Application no: H11-1020-11

Description: Extension to dwelling

Location: Rushfield
Jarvis Gate
Sutton St James
Spalding
PE12 0EU
PE12 0EU

Amendment: Amendment to show sloping roof

PROPOSED ELEVATIONS
SCALE 1:50

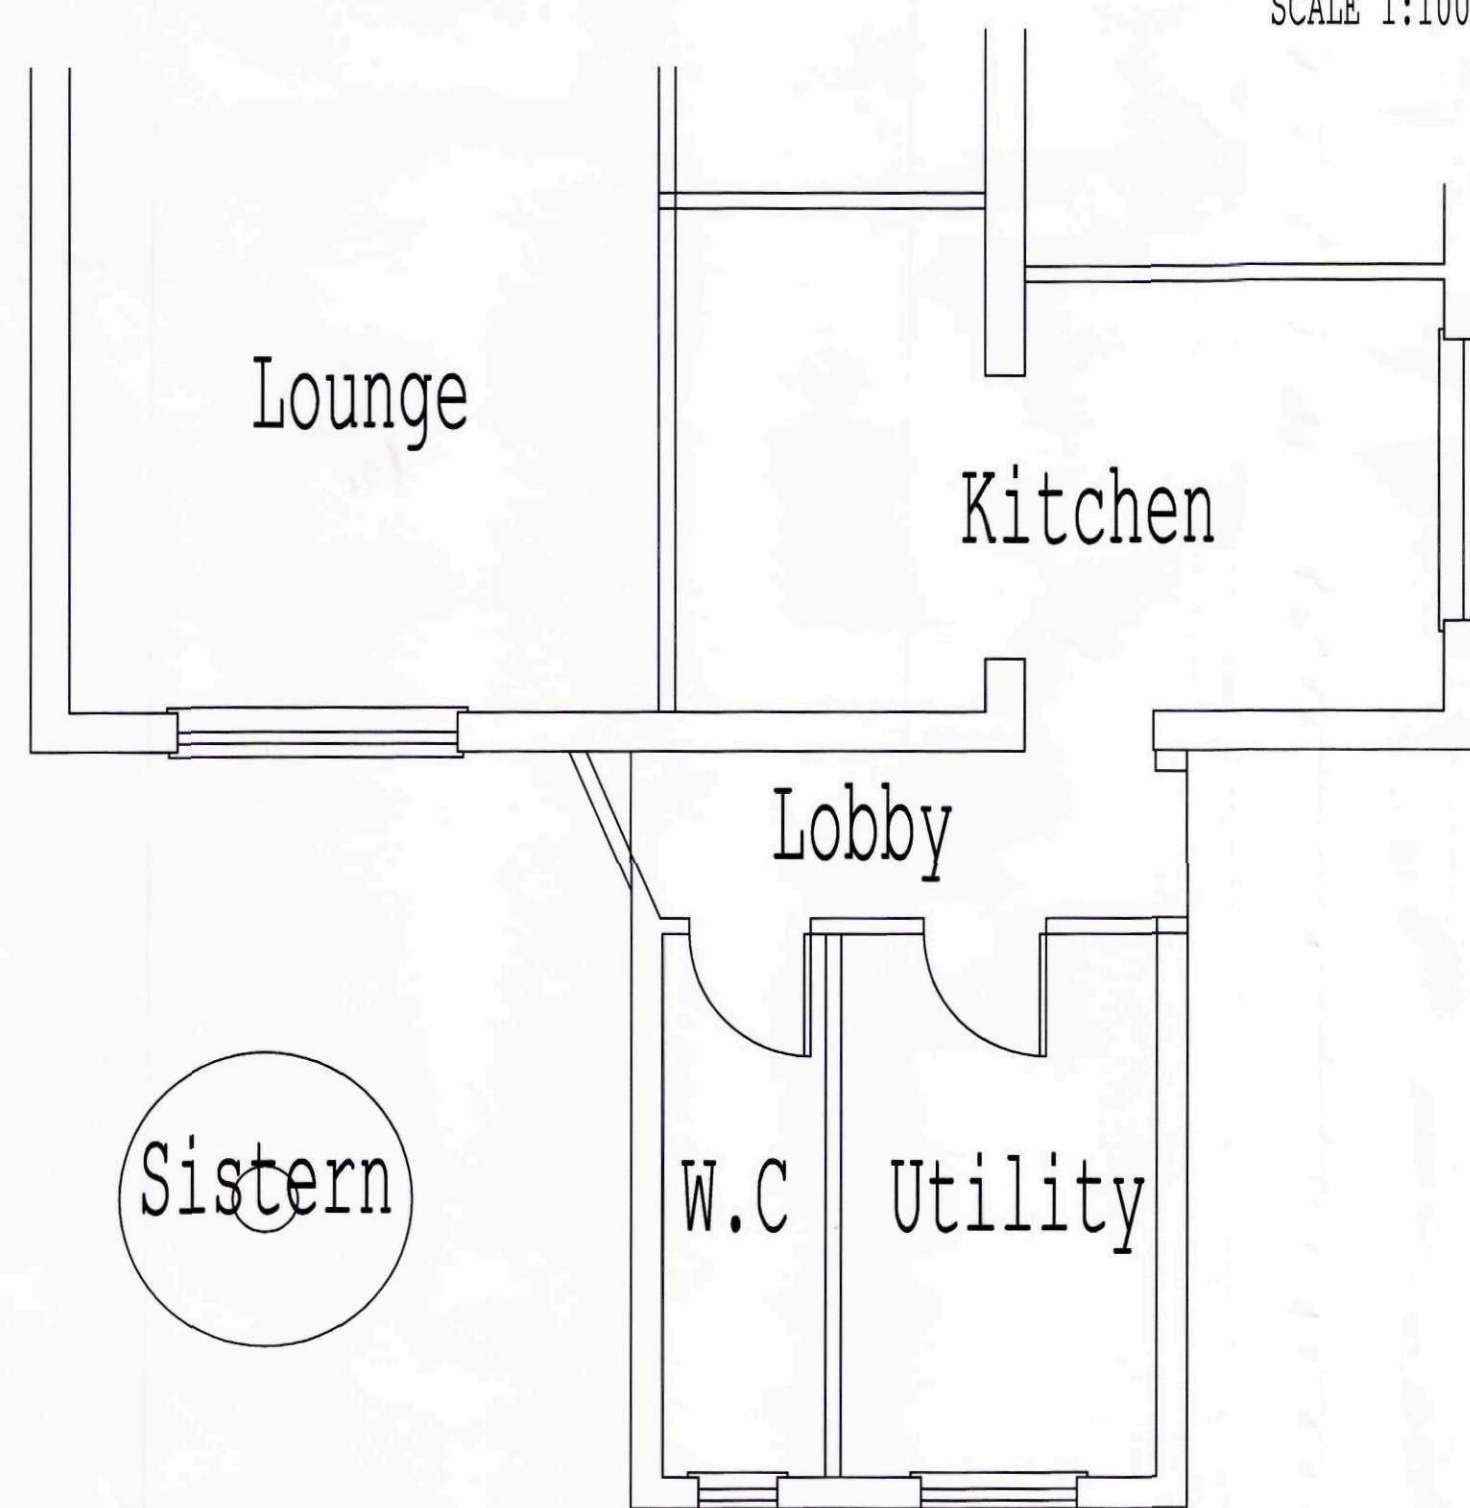
I attach a revised plan indicating a slopping roof as discussed
